**KIRKLEES METROPOLITAN COUNCIL
INVESTMENT & REGENERATION SERVICE**

**DELEGATED DECISION TO DETERMINE APPLICATIONS FOR
CONSENT, AGREEMENT OR APPROVAL REQUIRED BY CONDITION**

Reference No:	2024/44/92228/E
Site Address:	Batley Shopping Centre, Alfreds Way, Batley, WF17 5DR
Description:	Discharge of details reserved by conditions 4 (site investigations), 6 (Phase I Desk Study Report), 7 (groundworks), 8 (Phase II Intrusive Site Investigation Report), 14 (drainage) on previous permission for 2023/93630 for erection of detached 2 storey building to form 3 retail units on the ground floor with shisha lounge above
Recommending Officer:	Edward Cheseldine

Officer Report

FIGURE 4 - GROUTING PLAN

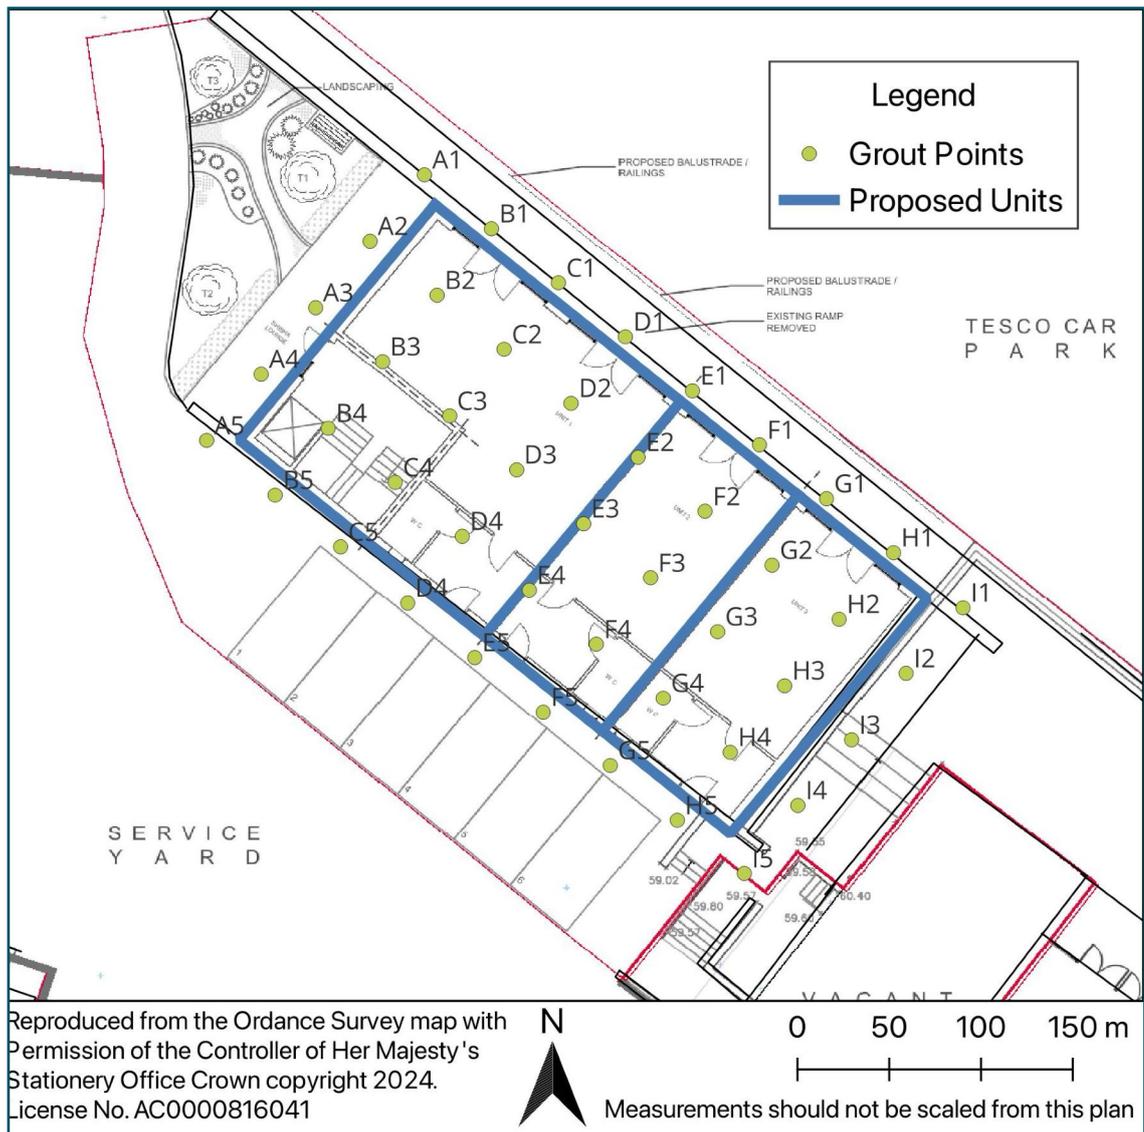
The report indicates that an intrusive investigation, comprising the drilling of two rotary openhole boreholes to depths of 30.0m bgl, was carried out at the site in order to establish the shallow coal mining situation. It advises that evidence of a worked coal seam was encountered at shallow depth. Due to the depth and thickness of the workings, the report goes on to detail a proposed drilling and grouting exercise to be carried out on a grid pattern across the footprint of the proposed building in order to stabilise/consolidate any workings present (as per report Figure 4).

The Coal Authority's Planning & Development Team welcomes the investigatory works carried out and the applicant's apparent intention to undertake drilling and grouting works to stabilise the shallow workings. However, as these remedial works have not been carried out (as required by part b) of the condition, we are unable to recommend that the LPA should discharge Condition 4 of the issued consent at this time.

Remedial works have not been implemented therefore criterion b) has not been met.

As the remedial works have not been carried out, it is not possible to discharge this condition.

Permission must be sought from The Coal Authority's Permitting and Licensing Team before undertaking any remedial works.
